SUBJECT: RIO GRANDE HOUSING
2334 Rio Grande Blvd NW
Site Plan for Building Permit
Project 1009204

Submitted herewith in support of final signoff by DRB is one copy of the Site Plan for Building Permit, revised to address EPC conditions of approval, as outlined in the Official Notification of Decision, dated May, 10, 2012.

CONCEPTUAL GRADING AND DRAINAGE PLAN

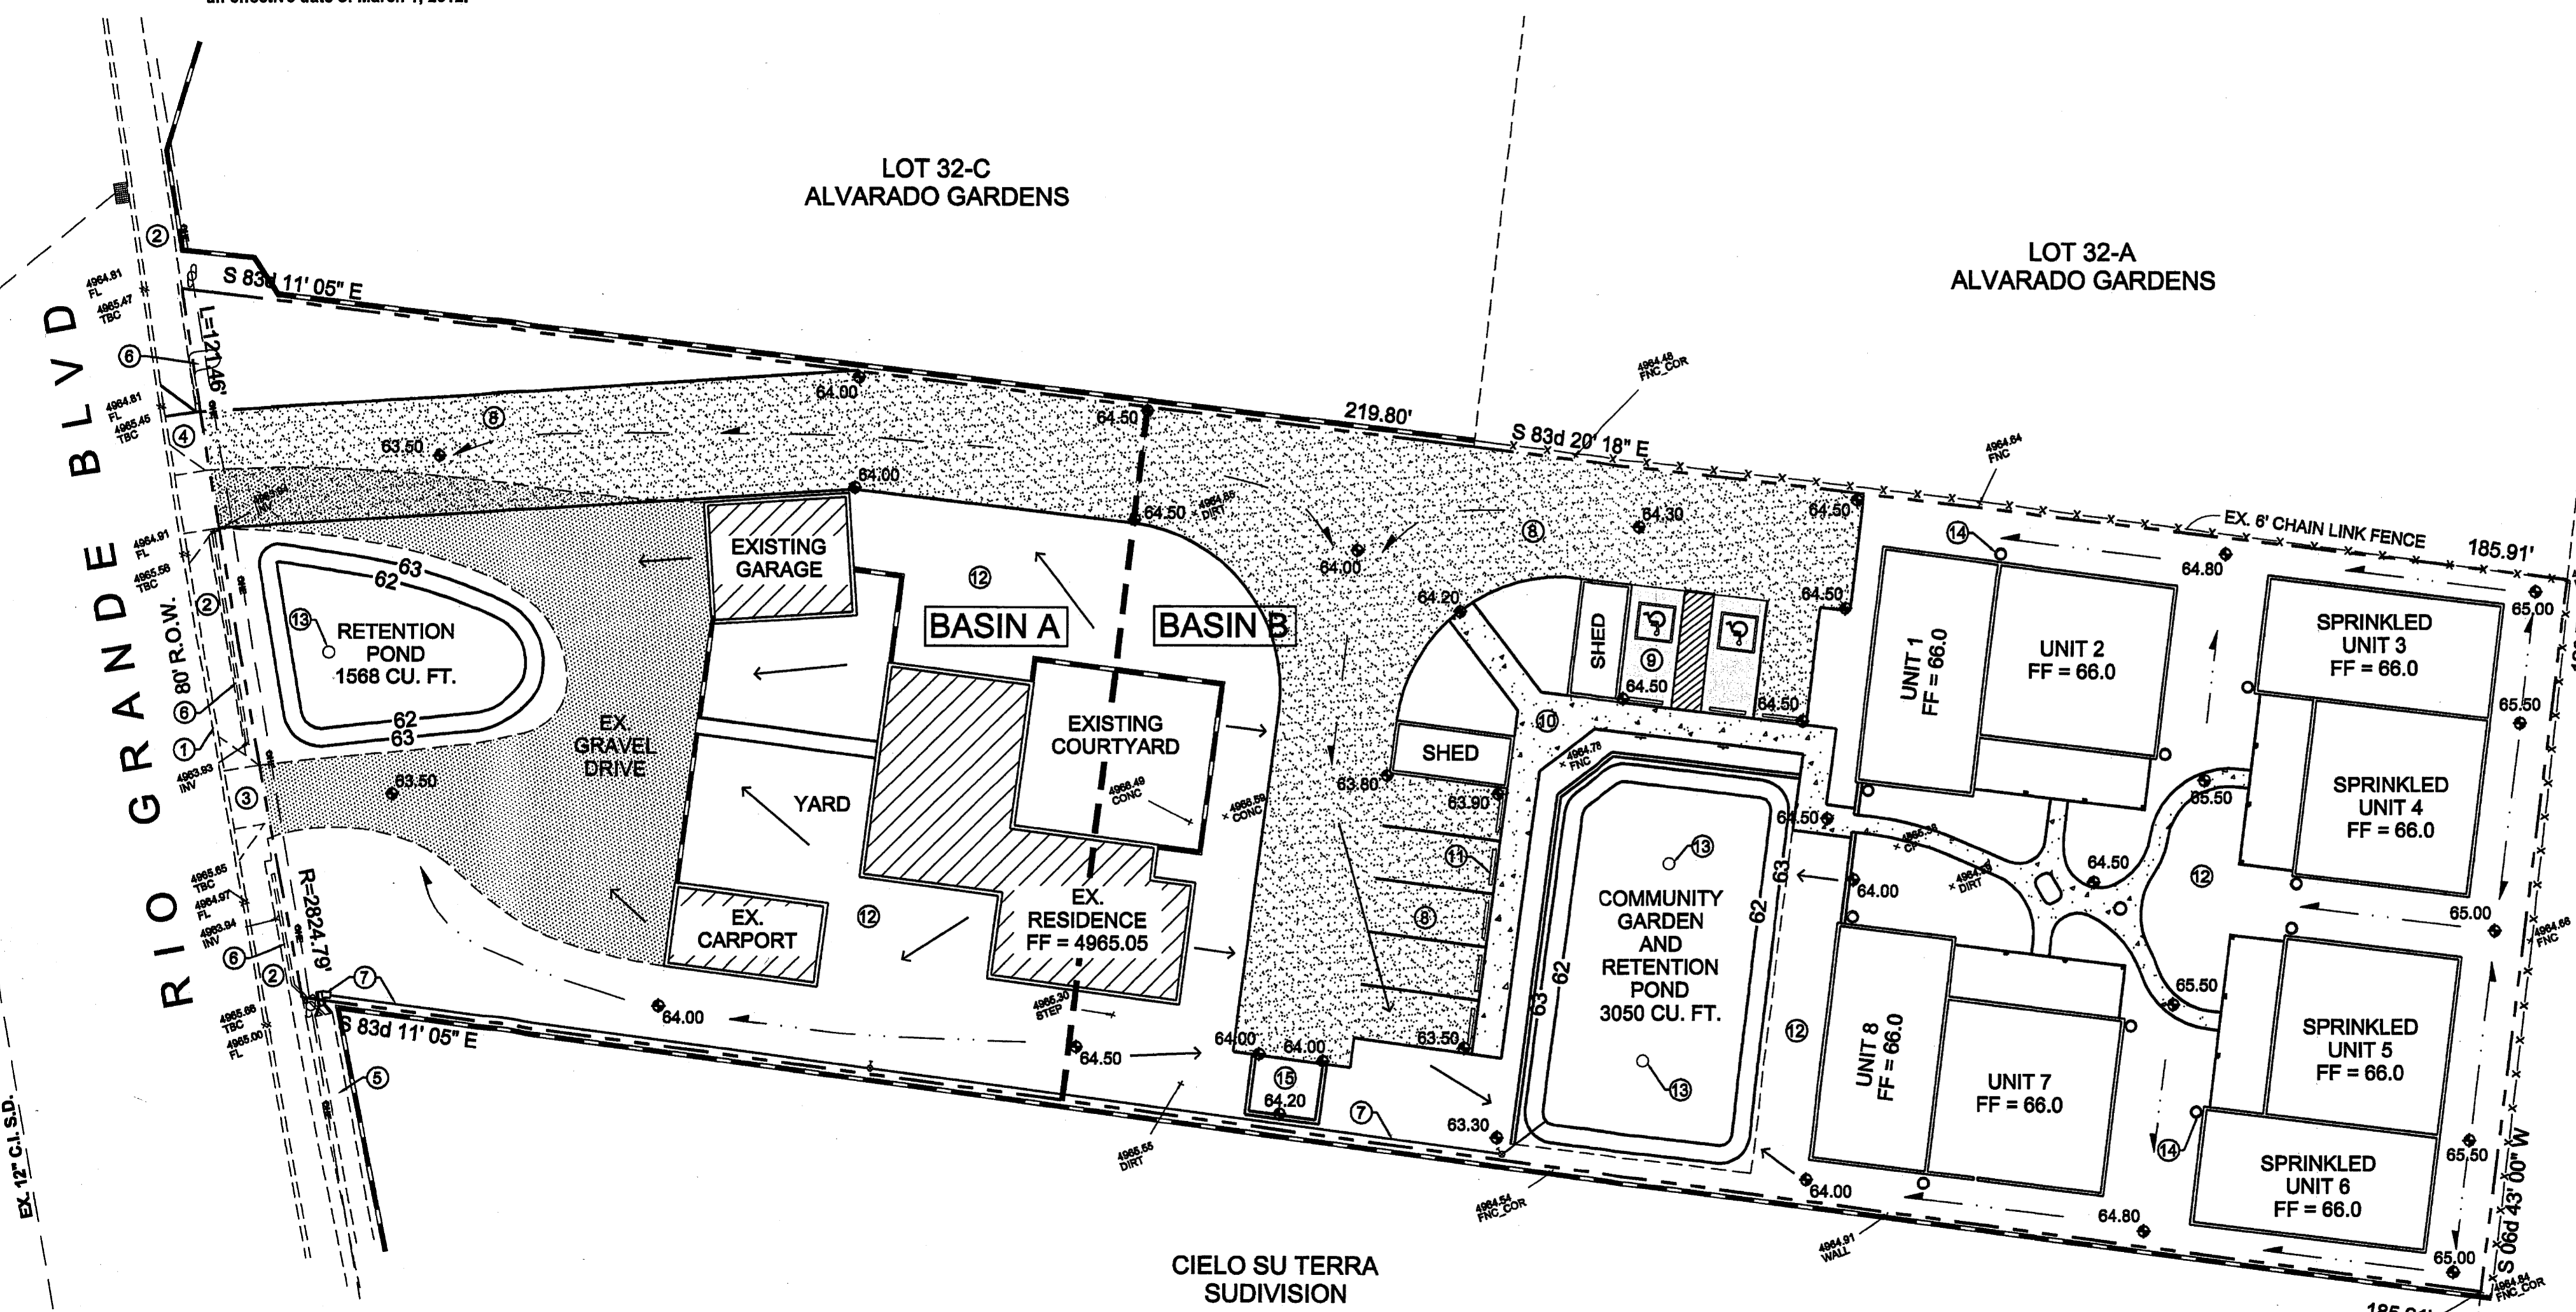
- f. All easements are shown on the Plan.
 - g. The Site Plan complies with DPM standards.
 - h. The note "The City of Albuquerque has received its EPA MS4 Permit of storm water quality with an effective date of March 1, 2012" has been placed on the Conceptual Grading and Drainage Plan.

BUILDING ELEVATIONS
SITE DEVELOPMENT PLAN FOR BUILDING PERMIT
RIO GRANDE HOUSING
2334 RIO GRANDE BLVD

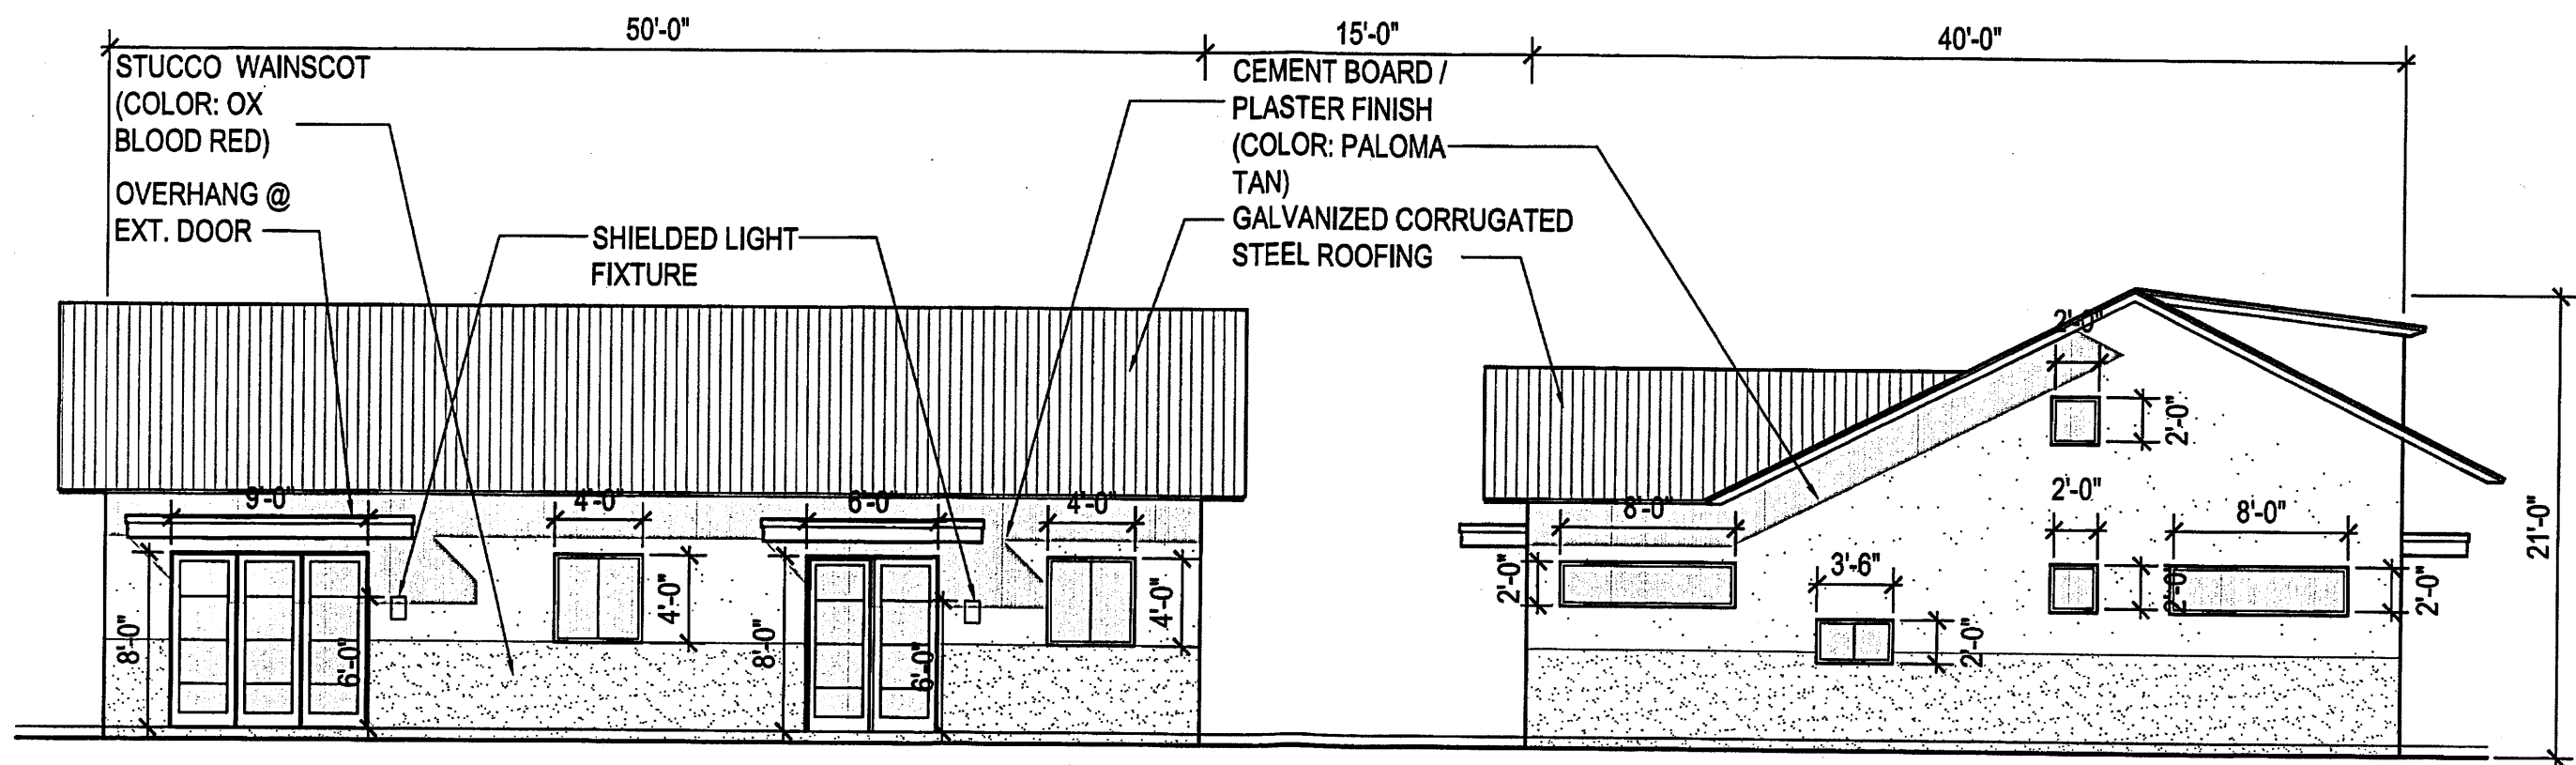
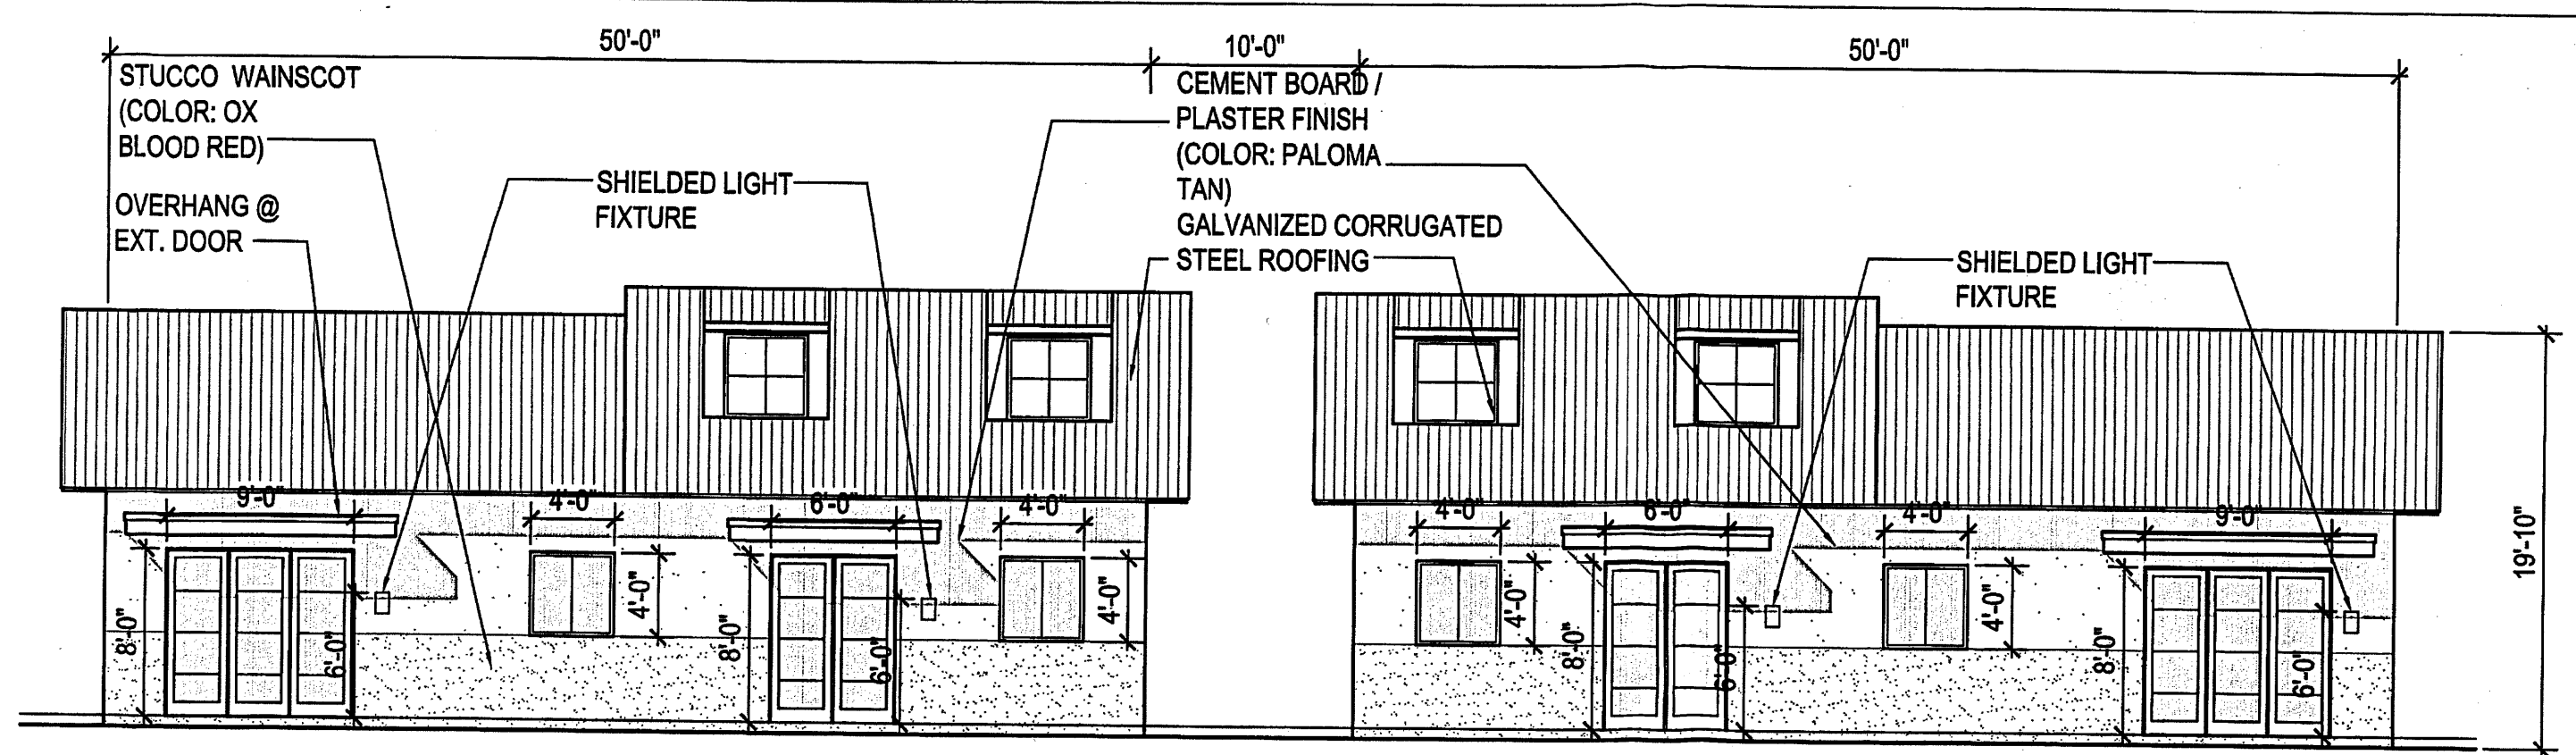
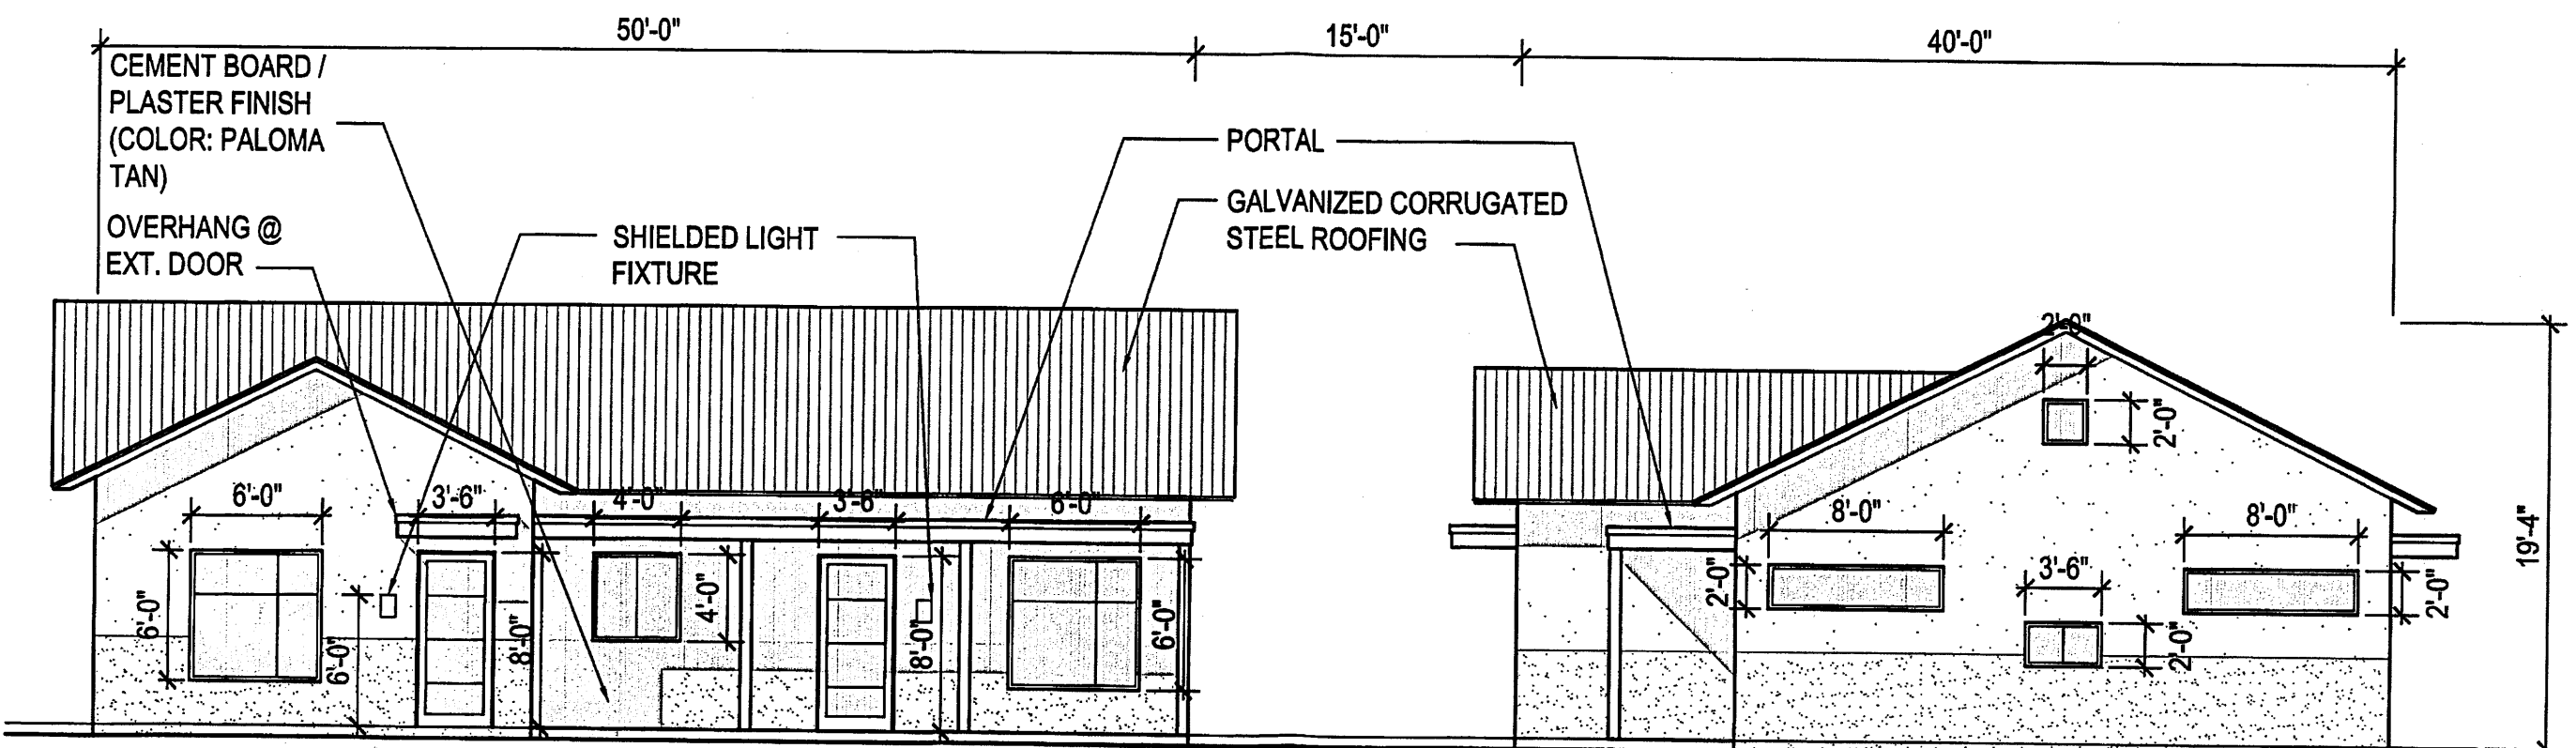
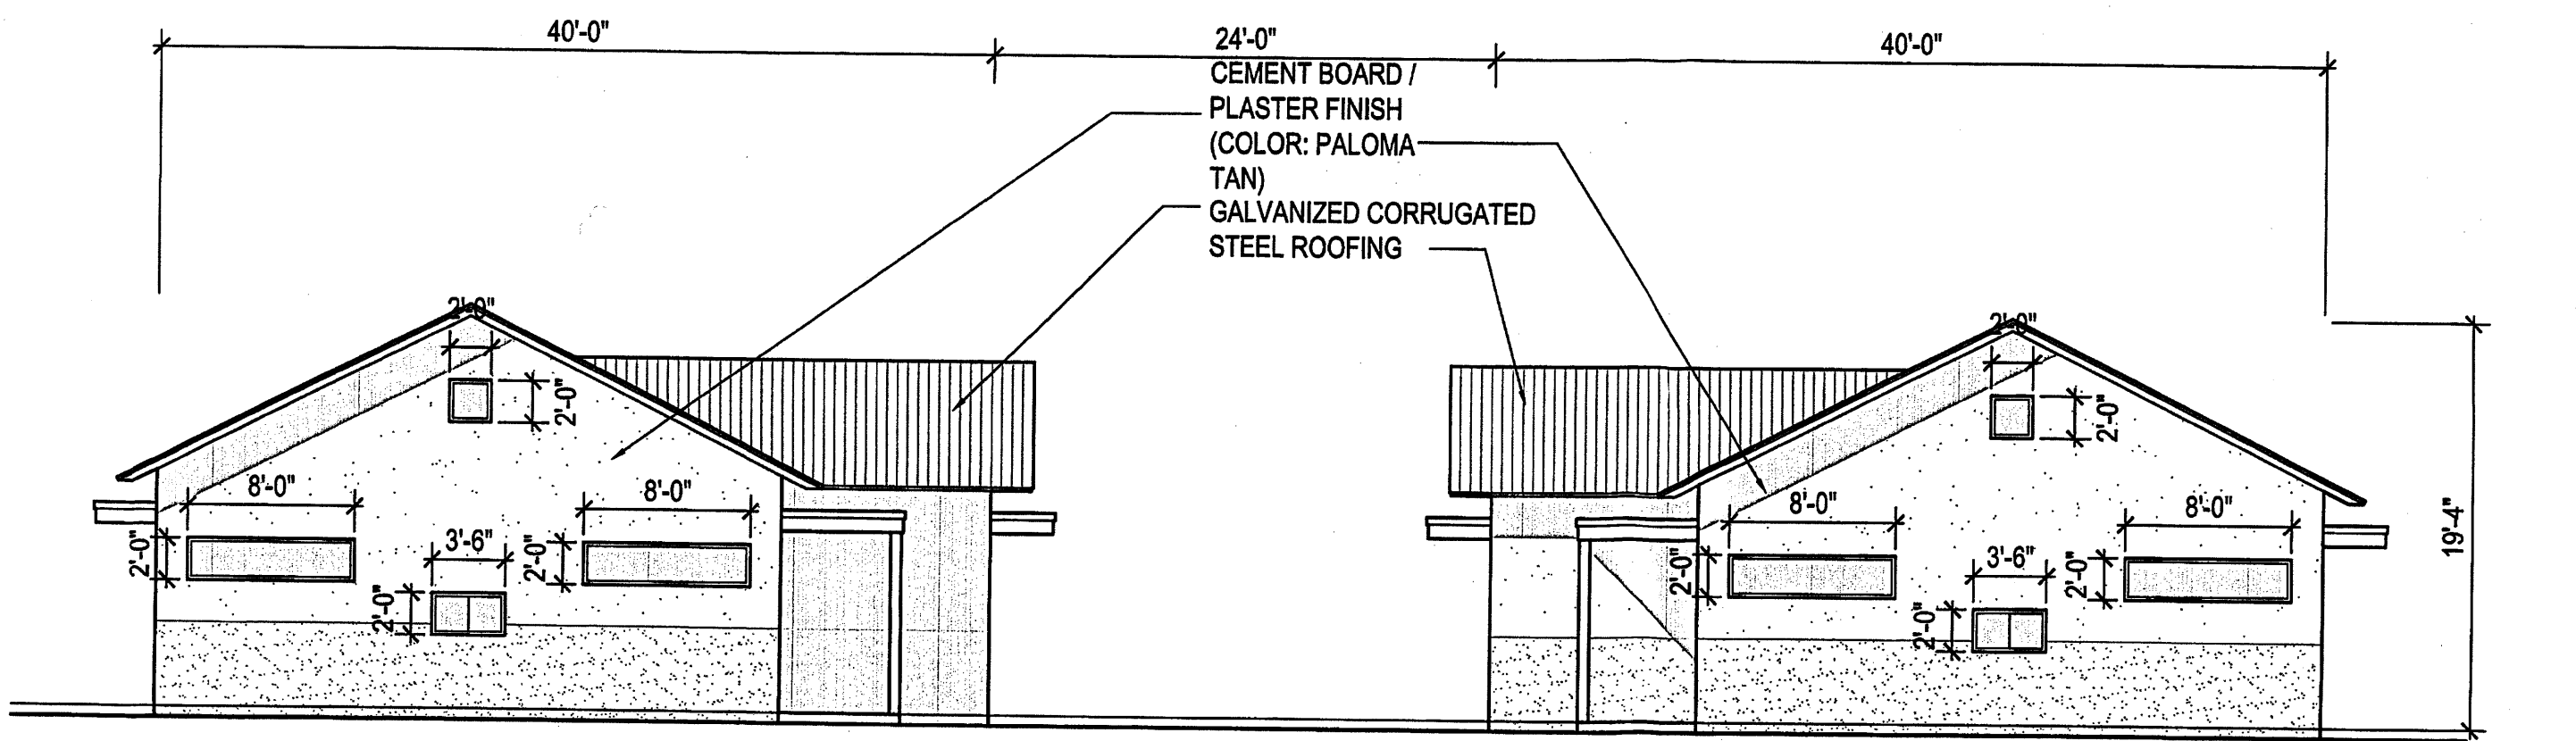
11. The landscaping shown on the Landscaping Plan matches the Landscaping Legend.
 12. The maximum building height of 24 feet to the top of the pitch is noted on the building elevations.
